Town & Country Planning Act 1990 (as amended)
Town and Country Planning (Development Management Procedure) (England) Order 2015
Approval of matters reserved by condition imposed under BE/18/17/PL relating to conditions 4-archaeological works, 5-surface water drainage, 9-landscape scheme, 10-protection of existing trees/bushes/shrubs, 14-foul drainage, 15-ecological enhancement scheme, 17-landscape management plan, 18-details of laying out timetable for provisions & future maintenance of Public Open spaces, 20-10% decentralised & renewable or low carbon energy sources, 21-street lighting scheme, 23-vehicle access, 25-car parking spaces, 27-construction of road(s), footways & casual parking areas & 28-Travel Plan statement.
Land West of New Barn Lane Bersted,,

Arun District Council have decided to **REFUSE details reserved by condition for the following reasons:**

The application to discharge Condition 5 imposed under reference BE/18/17/PL is refused by virtue of insufficient detail. The following detail is absent from the submission and should be incorporated as part of any future application to discharge this condition:

CPM3

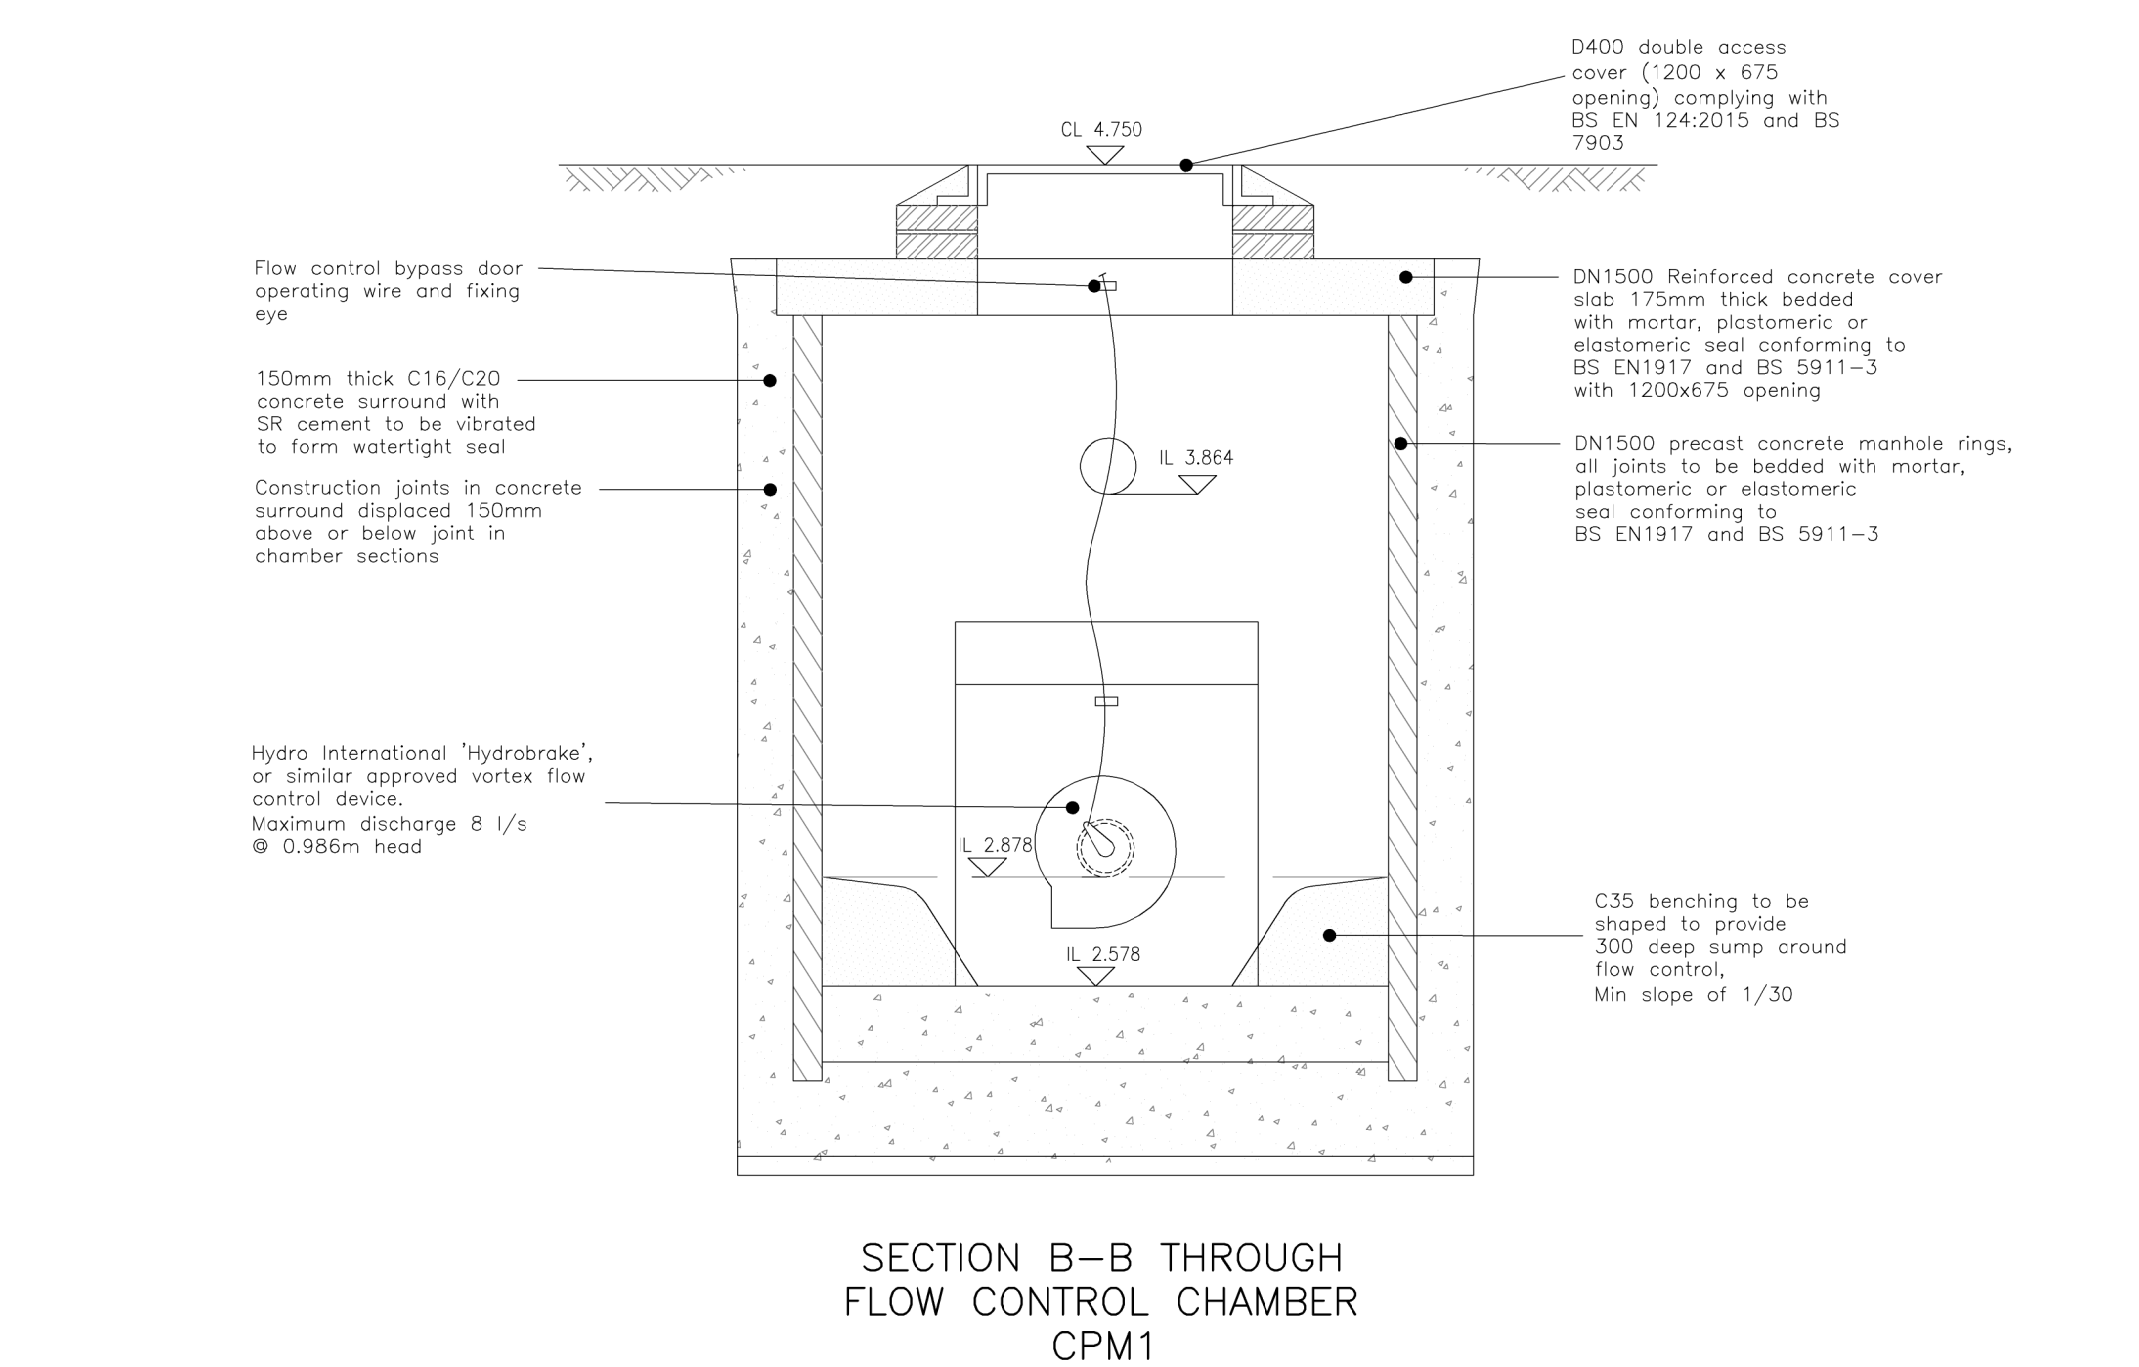
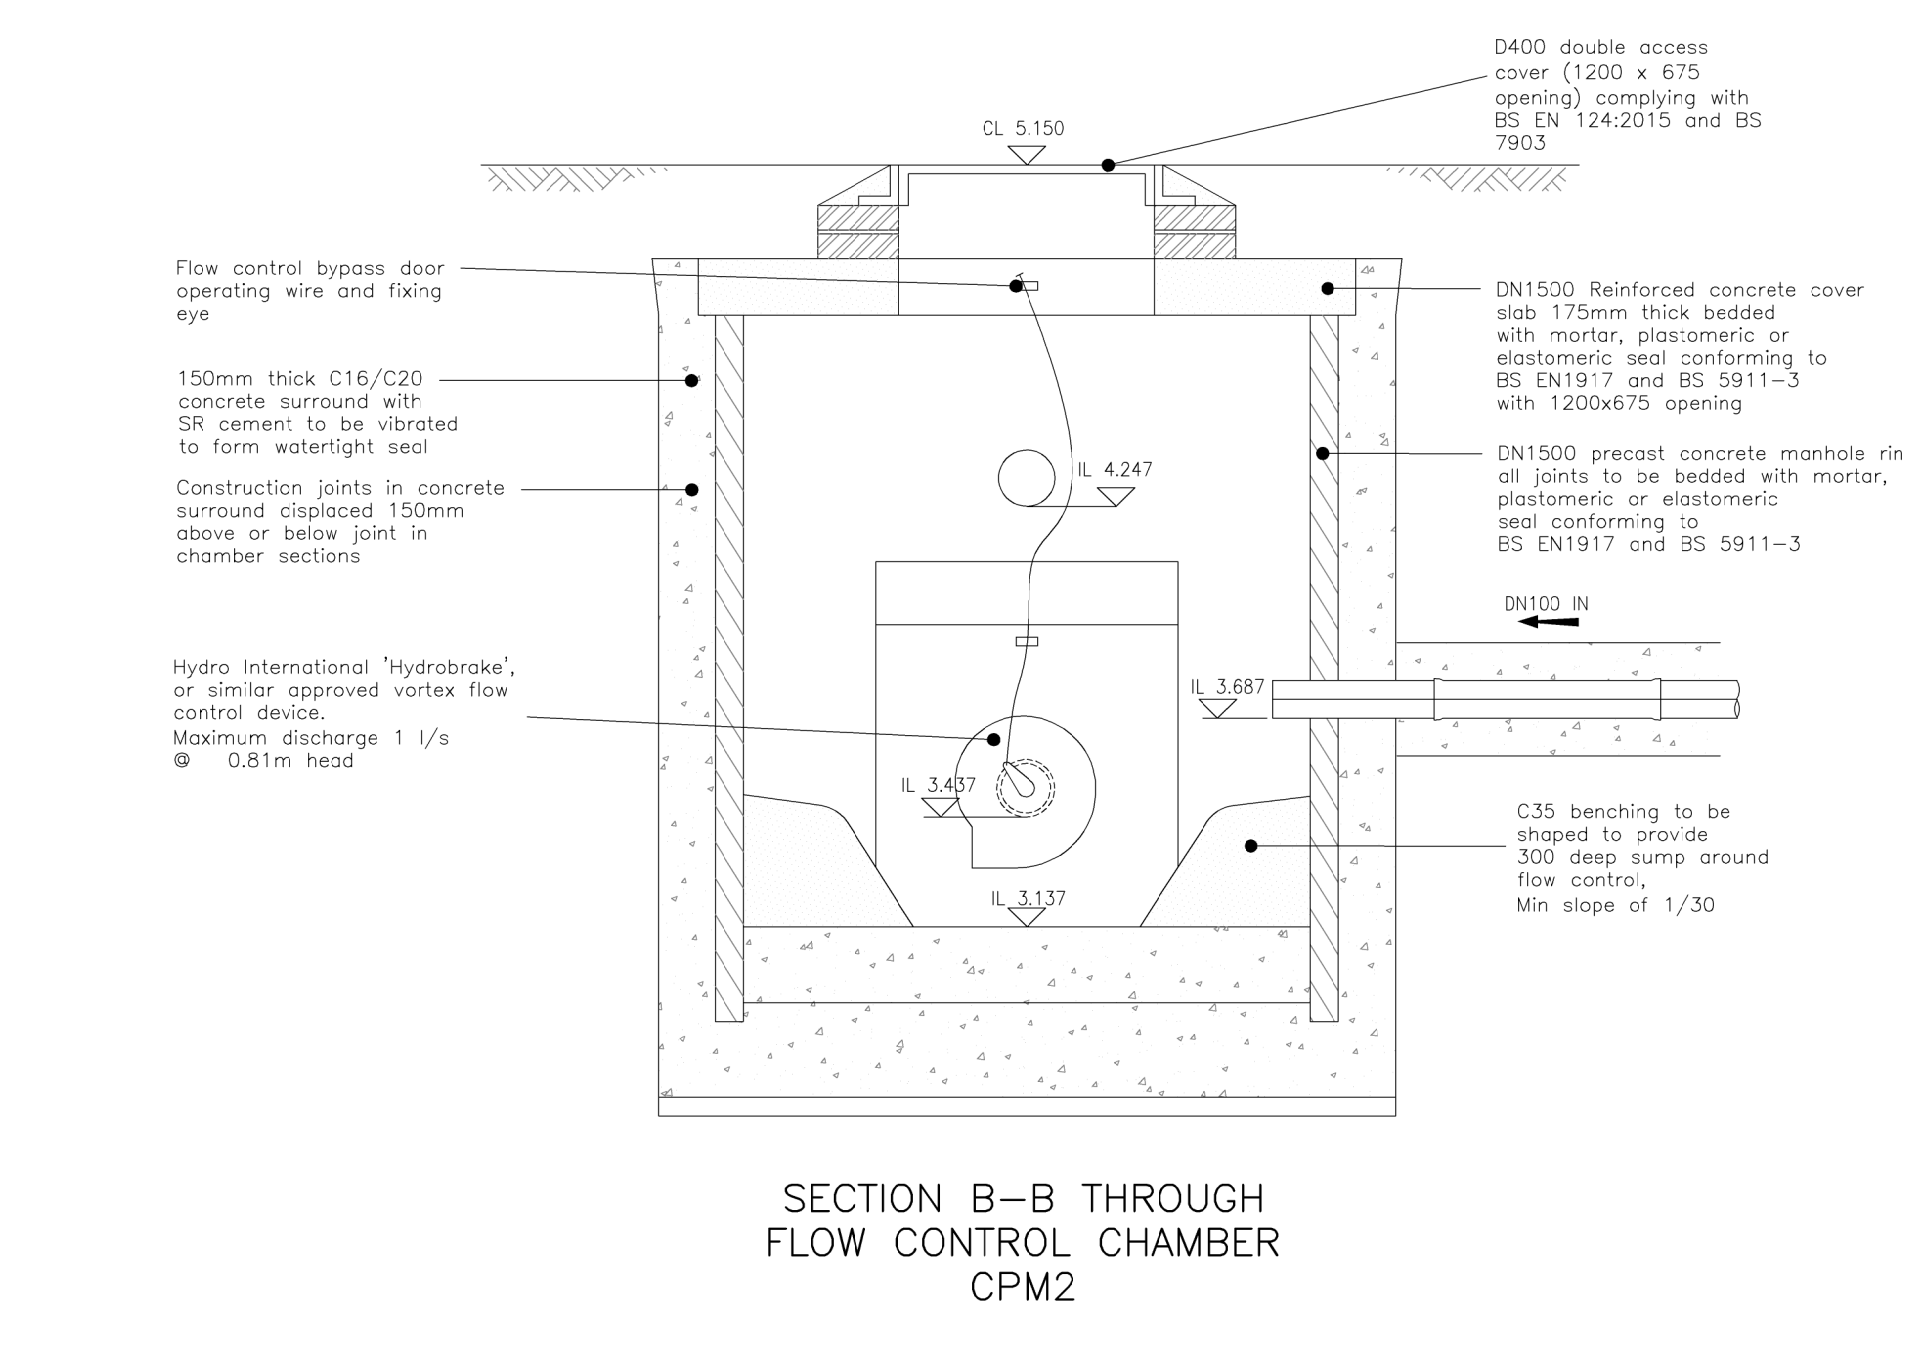
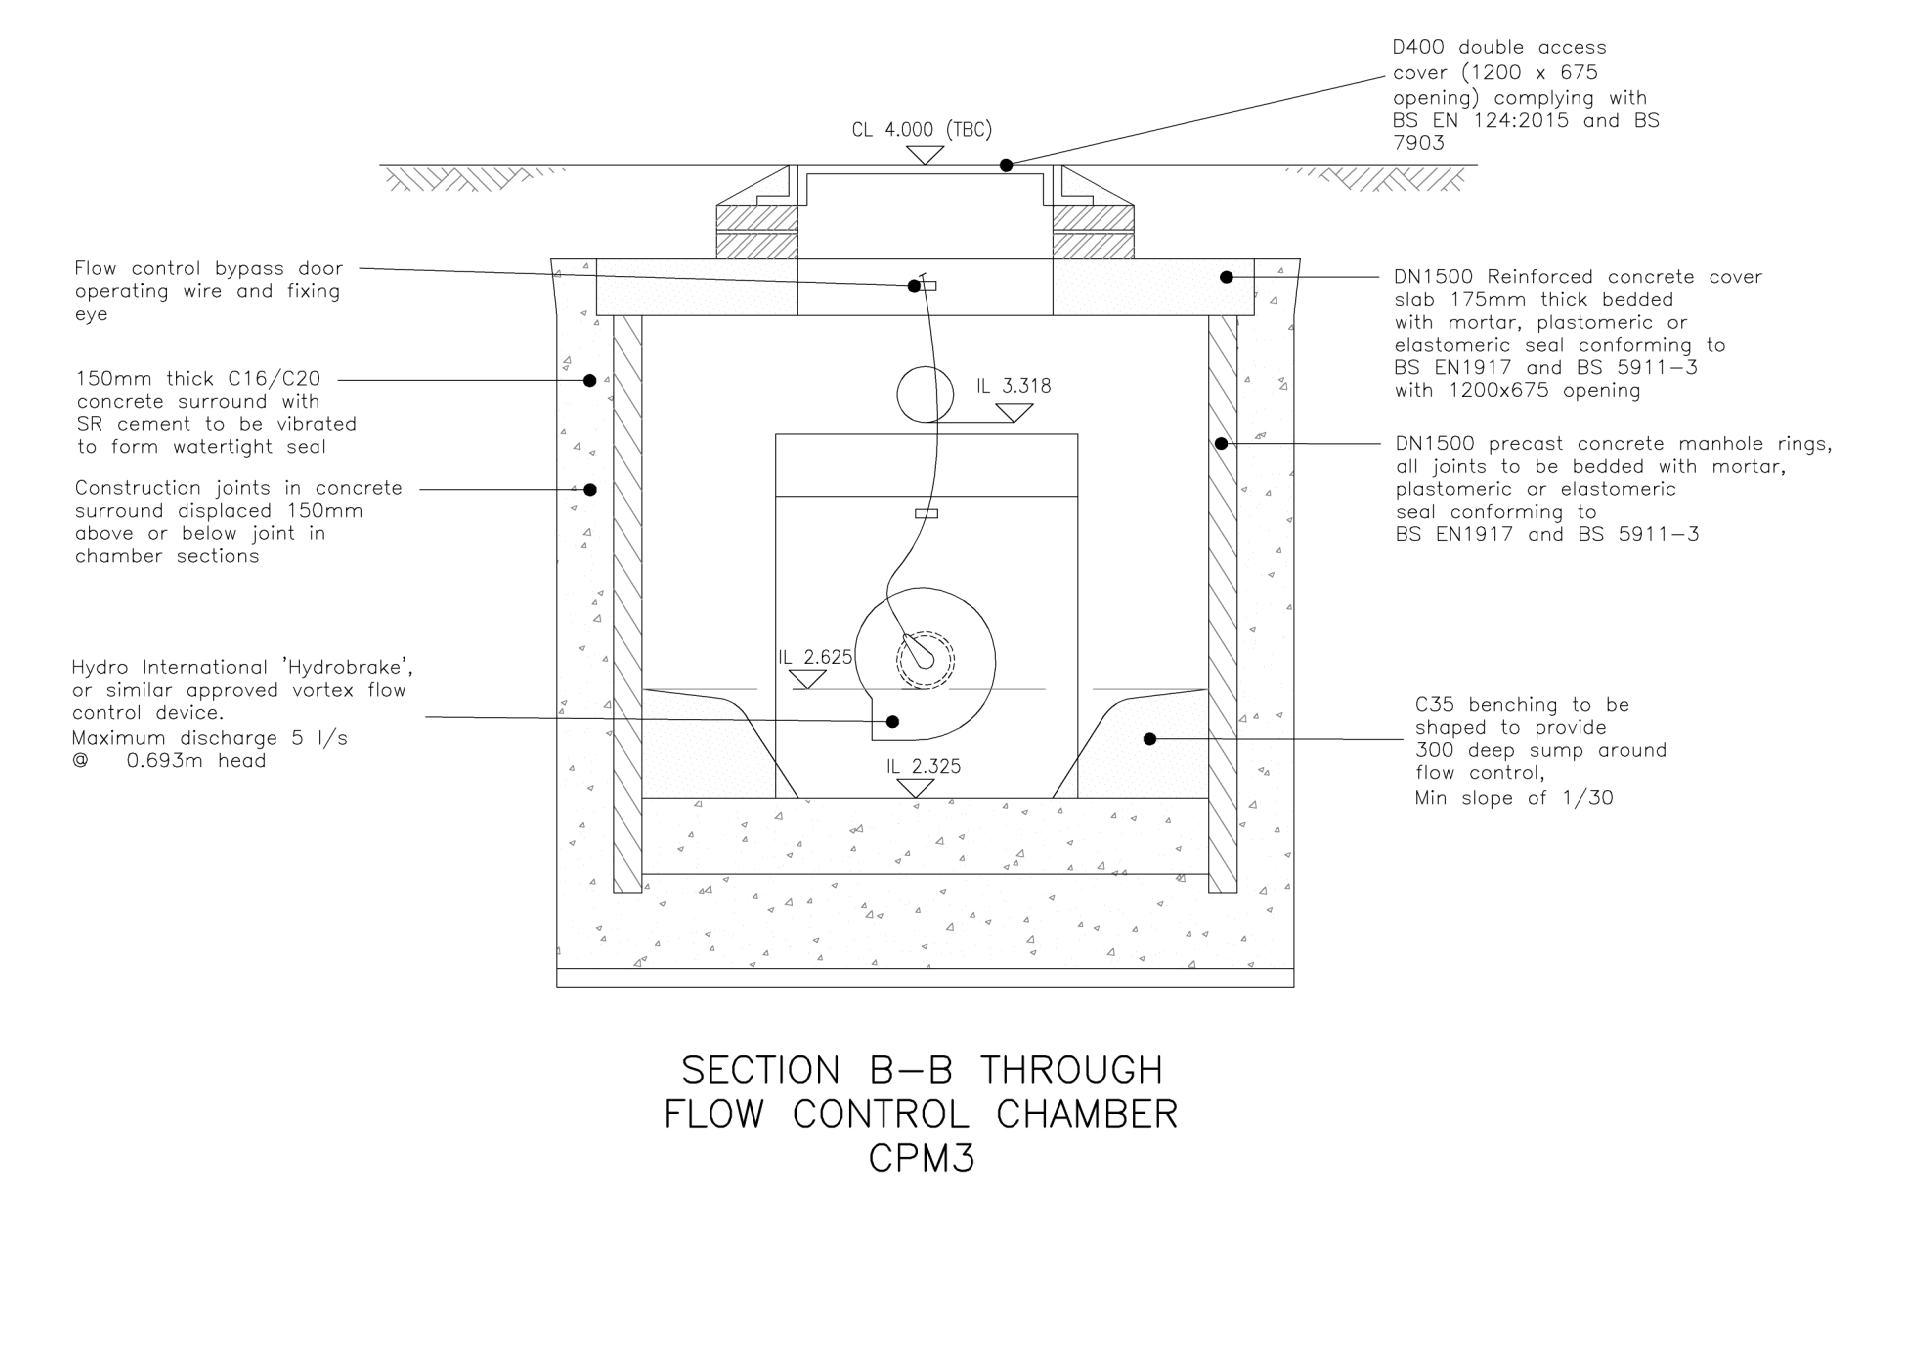
- Hydrobrake flow rates have been specified on the layout plans. However, confirmation is required that 1l/s flow restriction rate at CPM2 is achievable without risk of blockage?

- Pipe diameter downstream of SW1 has not been provided on the layout plan.
- Overflows have been included in the control chambers. Please provide for these in the microdrainage results, and show that they are not active during the 100 year plus climate change event.
